Sea Link

Document 7.4.10: Draft Statement of Common Ground Between National Grid Electricity Transmission and the Maritime and Coastguard Agency.

Planning Inspectorate Reference: EN020026

Version: BC
November 2025
January 2026

**Plate 5.1 Calculated maximum magnetic fields horizontally along the seabed for bundled cables, 0.5 m depth.**

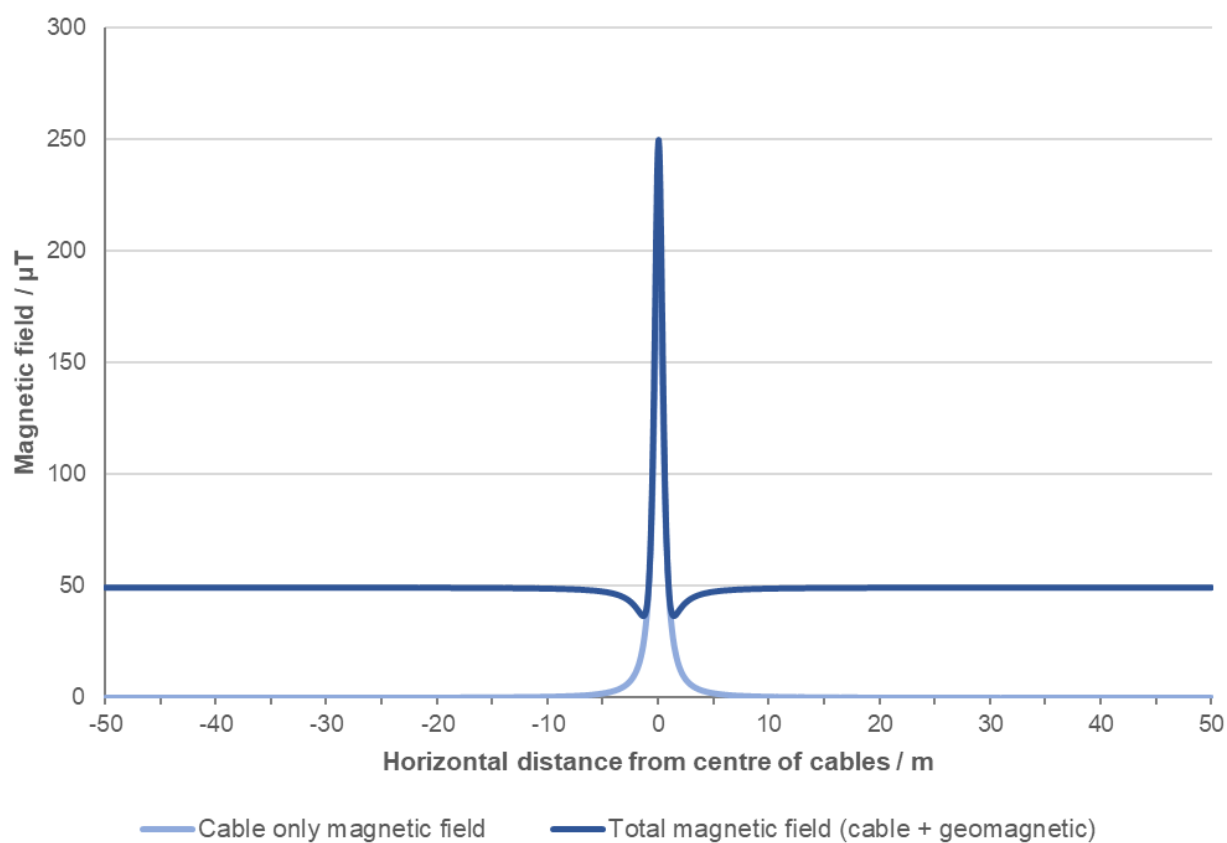
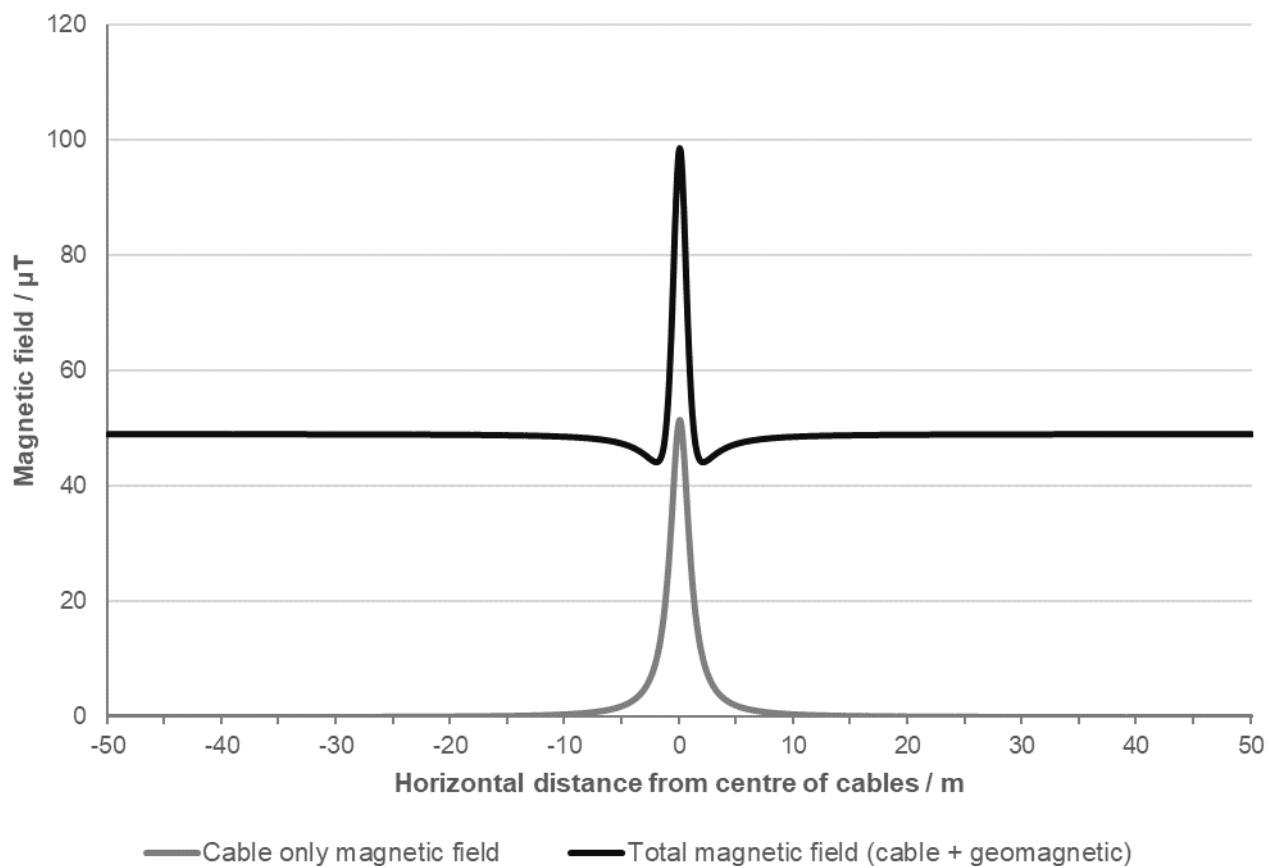
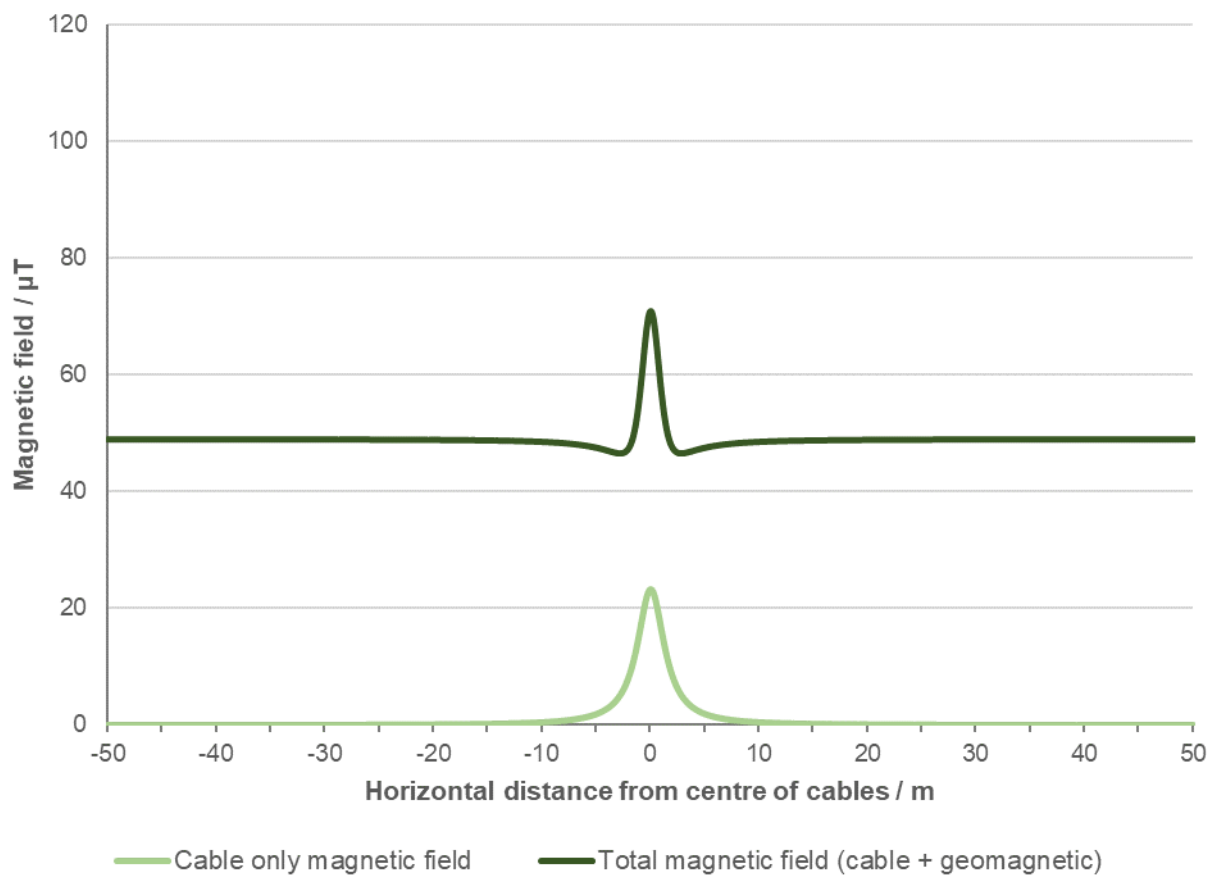
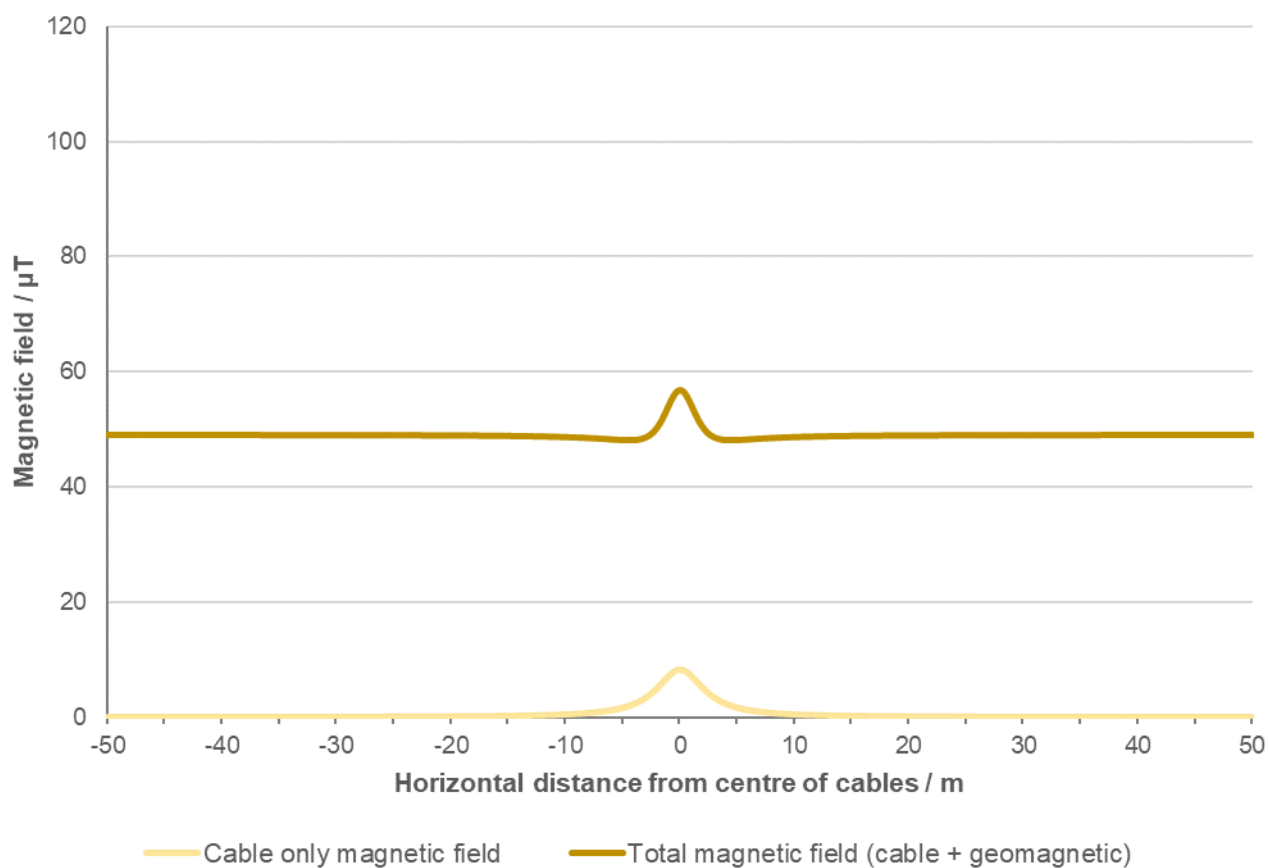
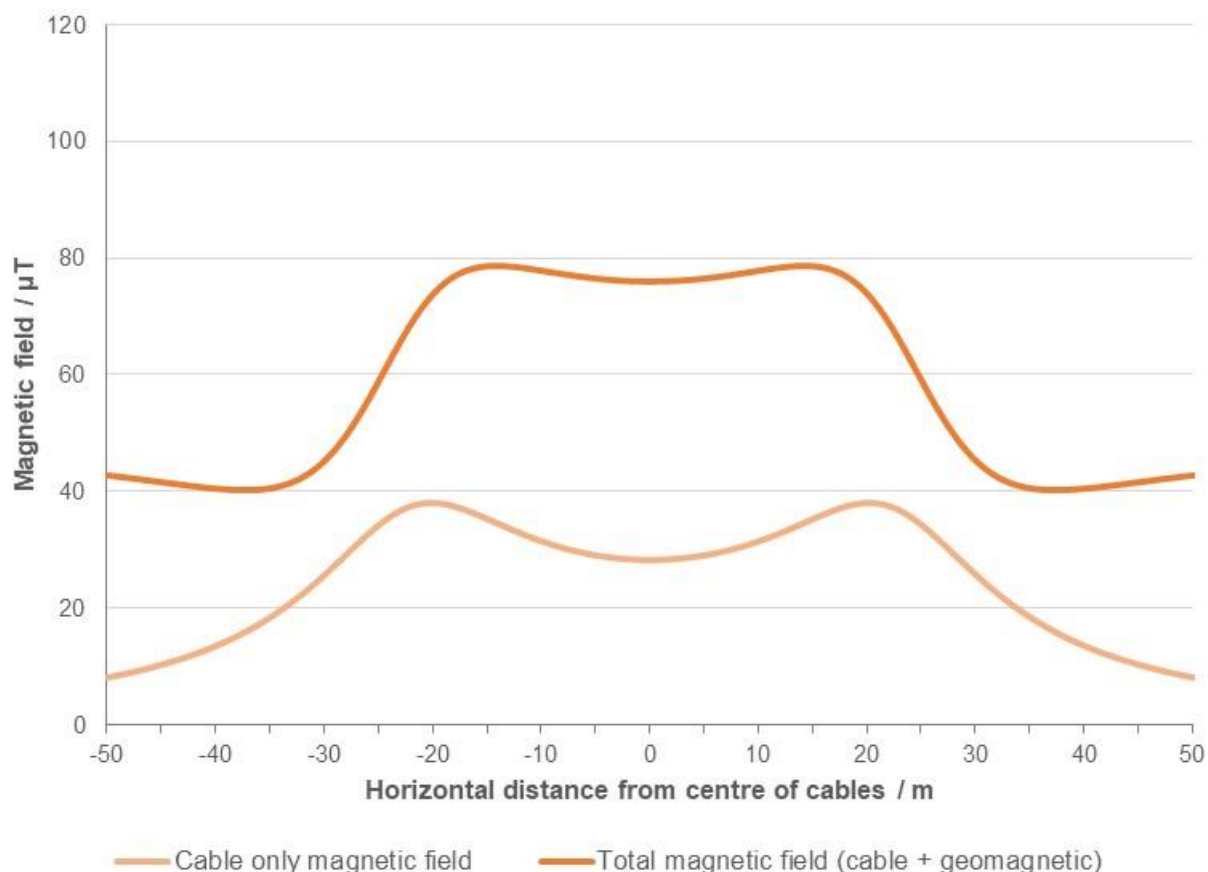
3.2.15	Application Document 6.5 Electric and Magnetic Field Compliance Report [APP-289]	Electromagnetic deviation	<p>The MCA has reviewed the Electric and Magnetic Field Compliance Report for the Sea Link HVDC cable. We confirm that the offshore section complies with our requirements; less than 3° deviation for 95% of the route and less than 5° for the remaining 5%, as detailed in Table 5.2 of the report.</p> <p>In nearshore areas where the cables are separated by 45m and buried to a depth of 10m (approximately 2.435 km in total—1.524 km along the Suffolk coast and 0.911 km in Pegwell Bay), no detailed electromagnetic field (EMF) assessment has been provided. While this segment represents only 2 % of the total route and vessel traffic is mostly perpendicular (minimising</p>	<p>The Applicant notes the Consultee's request that the maximum burial depth be used throughout the trenchless phase and to consider bundled lay as much as practically possible to further reduce any potential effects on vessel navigation.</p> <p>The Applicant notes the Consultee's request that should anything change with the current cable route, and it cannot be demonstrated that MCA deviation requirements can be met pre-construction, a post-</p>	Under discussion

Ref	Relevant Application Document	Summary of Description of Matter	MCA Current Position	The Applicant's Current Position	Status
	Application Document 6.2.1.4 Description of the Proposed Project [AS-093]		<p>interaction), the separation may result in compass deviations exceeding 5°.</p> <p>Although the navigational impact is expected to be minimal, the MCA requests that the project team ensure maximum burial depth throughout the trenchless phase and to consider bundled lay as much as practically possible to further reduce any potential effects on vessel navigation. Should anything change with the current cable route, and it cannot be demonstrated that MCA deviation requirements can be met pre-construction, a post-construction compass deviation survey of the 'as laid' Offshore Cable Corridor may be required.</p>	<p>construction compass deviation survey of the 'as laid' Offshore Cable Corridor may be required.</p> <p>The Applicant confirms an initial high-level assessment has been undertaken in response to this comment in the MCA Relevant Representation and are confident they can meet the Consultee's requirements in this area. A full update to the EMF report will be carried out once a full analysis update had been carried out pre-construction and will be shared with the Consultee at the earliest opportunity.</p>

Plate 1.1 Cable route overview showing stakeholder areas of concern in relation to water depth

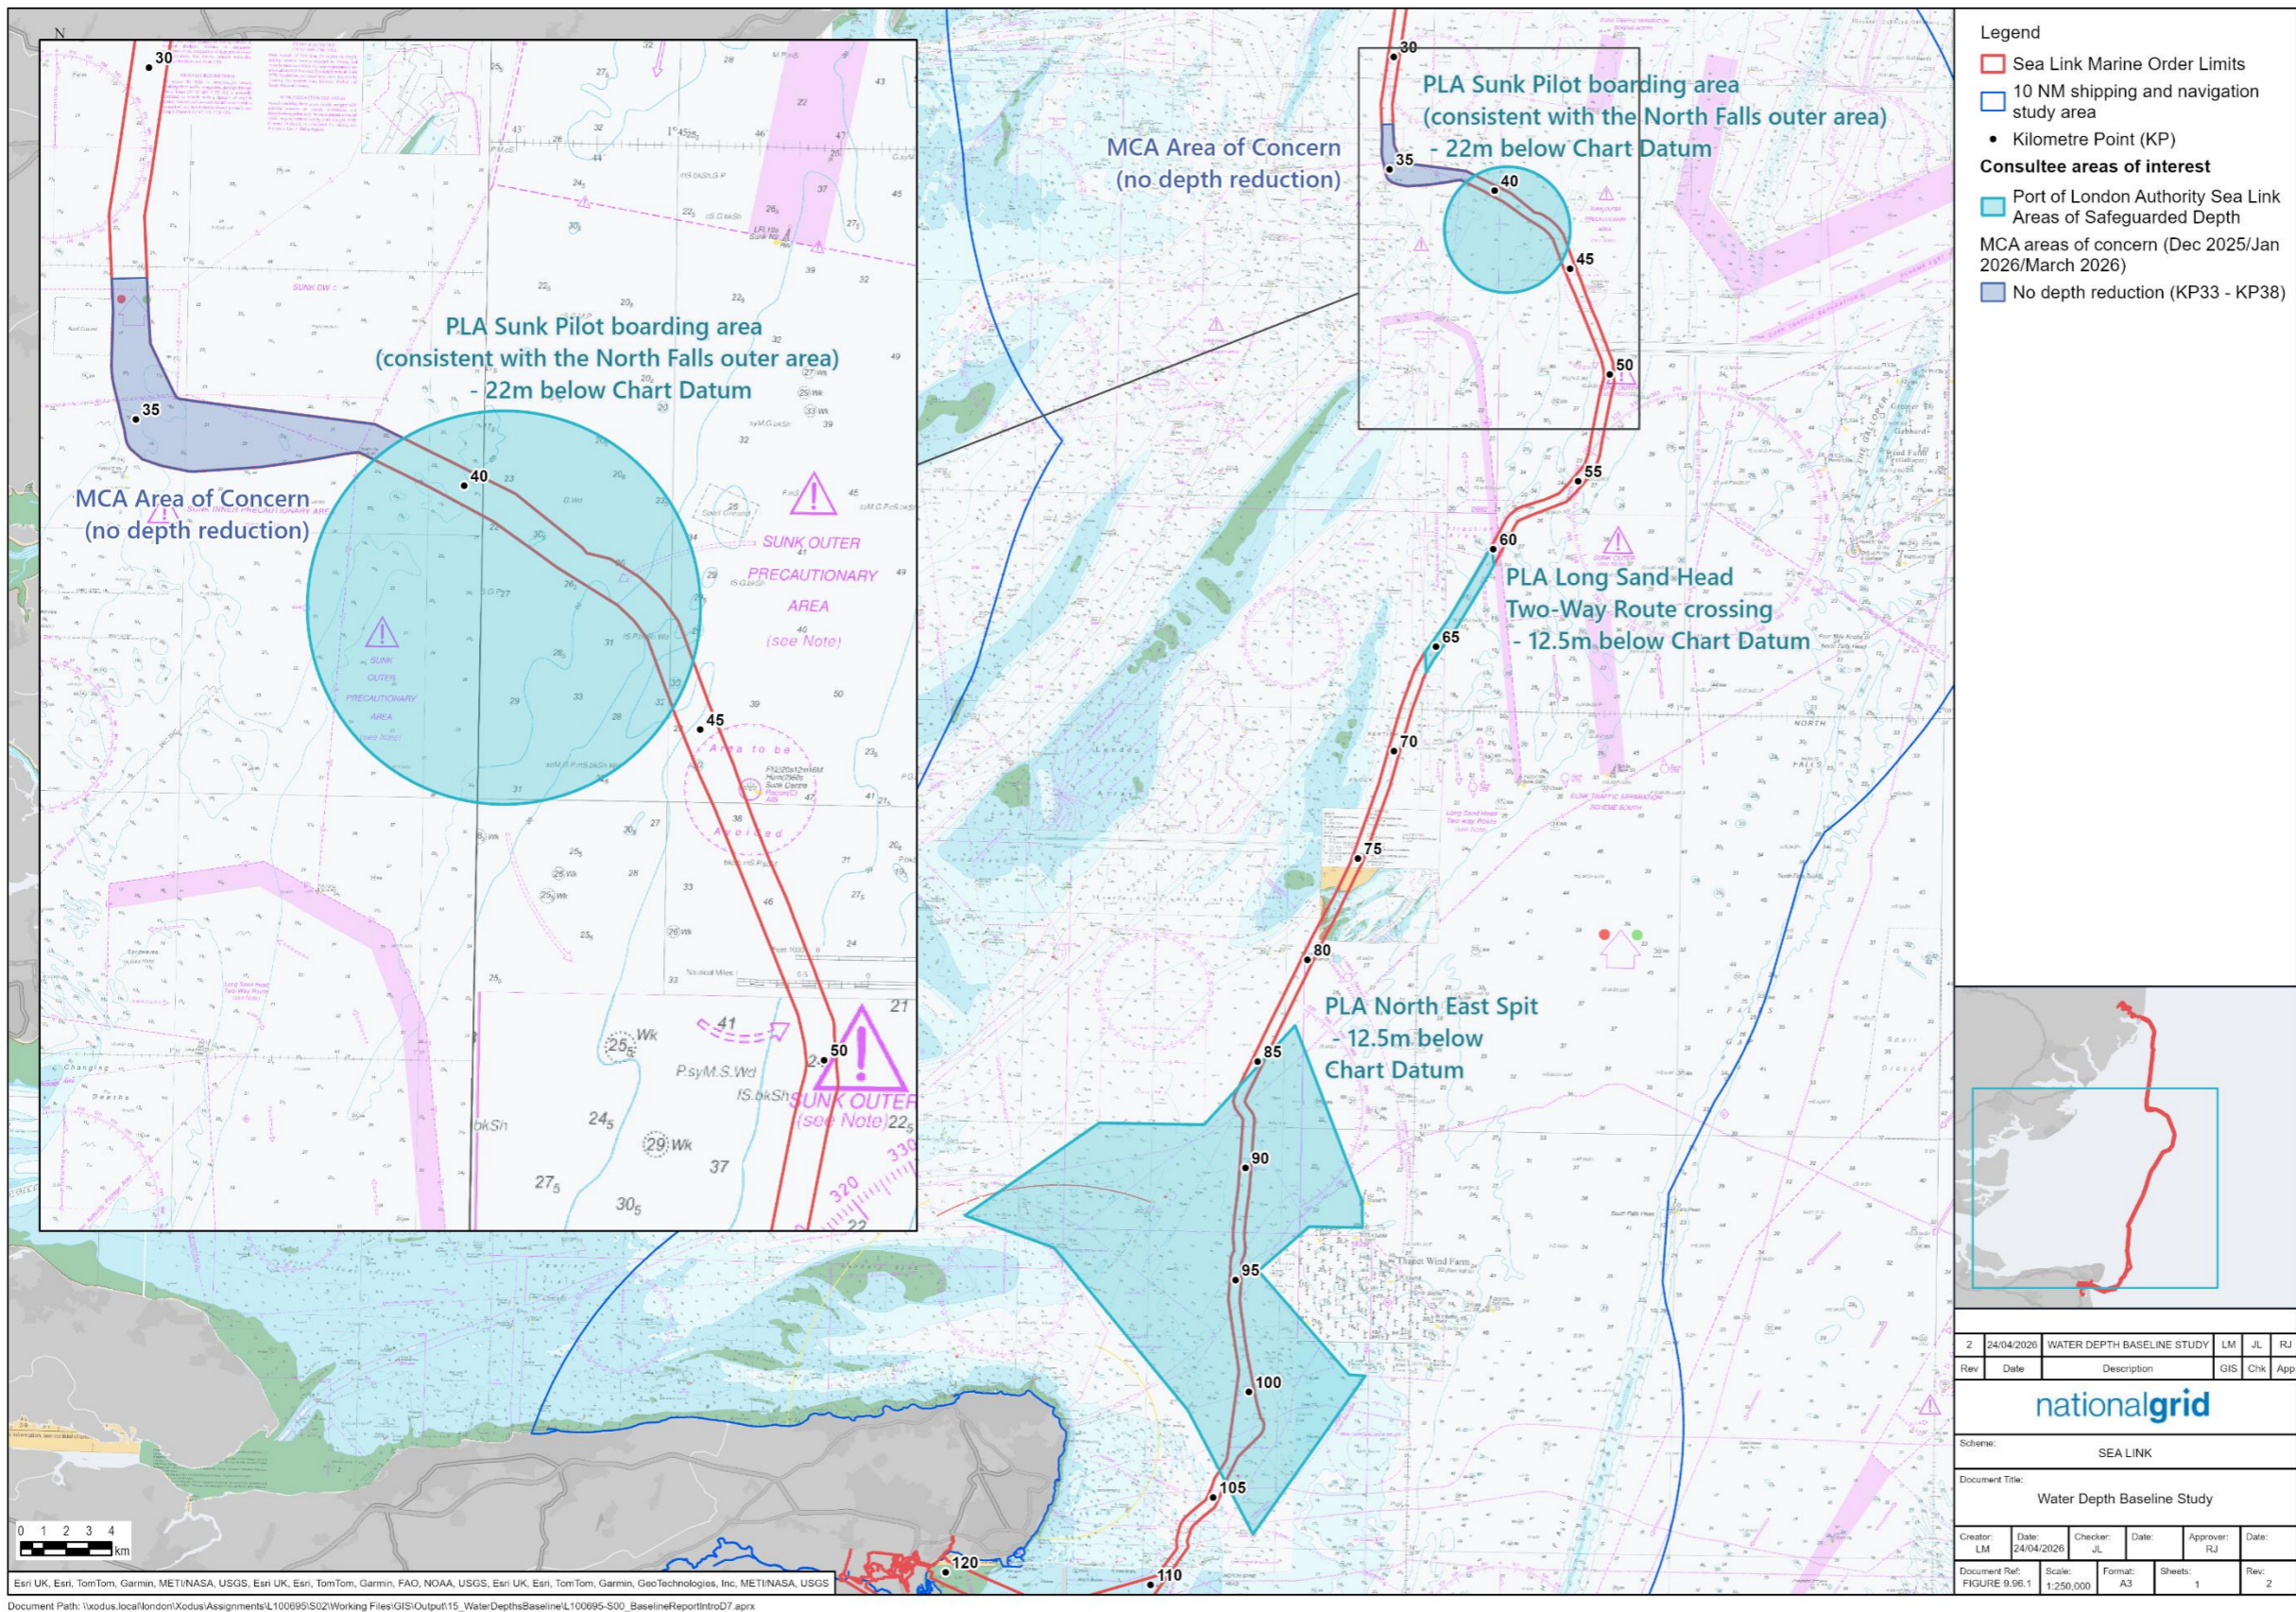
3.2.8	N/A	New MCA Areas of Interest, Dec 2025 Communications during construction phase	<p>(11 May 2021) The Consultee requested a notice to mariners to define what areas the marine survey vessels will be working in and on what days so the MCA can work with PLA and Harwich to manage other vessel traffic. The MCA are just about to do the same with another project.</p> <p><u>–The Consultee has provided the applicant with MCA's area of interest (AOI) for safeguarded 22m water depth, and the AOI for concurrent RAM and Restricted Visibility Stop Ops.</u></p> <p><u>The Consultee was asked if it had a preference for how to deal with notice and communication to mariners. The Consultee confirmed updates on a daily basis to help MCA plan movement would be helpful. On other projects they have received written statements and taken part in daily update calls.</u></p>	<p>The Applicant acknowledged the importance of maintaining effective communication with relevant stakeholders throughout the construction phase of the Sea Link Project. In response to requests for clear and timely updates during this period, the Applicant has incorporated communication protocols into its construction planning.</p> <p>To support this commitment, a Navigation Installation Plan (NIP) is being developed following the submission of the Development Consent Order (DCO) application. The NIP will serve as a key mechanism for disseminating information to mariners and other stakeholders regarding navigational considerations during construction.</p> <p>A draft Outline NIP was submitted to the Planning Inspectorate (PINS) on 1 September 2025, as part of the Applicant's response to the Examining Authority's Section 89(3) letter dated 5 August 2025. The Consultee has sent the Applicant four additional areas of interest, as follows:</p> <p><u>An extended area of safeguarded depth to 22 m (with 0.5 m over-dredge) in the Sunk Pilot Boarding area, extending between KP 33 to KP 45. This is to include areas closer to the Sunk Deep Water Anchorage as well.</u></p>	Under discussion

Ref	Relevant Application Document	Summary of Description of Matter	MCA Current Position	The Applicant's Current Position	Status
				<p><u>An extended area of avoiding concurrent RAM activities, from between KP 35 to Sunk Centre, to avoid SIMOPS with Five Estuaries and North Falls within the SUNK Outer Precautionary area where cable crossings are expected.</u></p> <p><u>The Restricted Visibility Stop Operation should be applied to the entire Sunk area KP 33 to KP 50.</u></p> <p><u>The MCA disagrees with the PLA and states that they believe 12.5 m safeguarding is not sufficient for the "Long Sand Head Two-Way Route Crossing area". The MCA establish an extended area including and beyond the Long Sand Head Two-Way Route Crossing area, within which the MCA will need more information and further consultation if there is any depth reduction, between KP 45 to KP85.</u></p> <p><u>The Applicant is seeking further clarity from the MCA on these new areas, which are substantially larger and more restrictive in their requirements than those which the Applicant and ports stakeholders have been collaborating on, and on which the Applicant and ports stakeholders have previously reached agreement. The Applicant will discuss this matter at a meeting with the MCA arranged on 16 January 2026.</u></p>
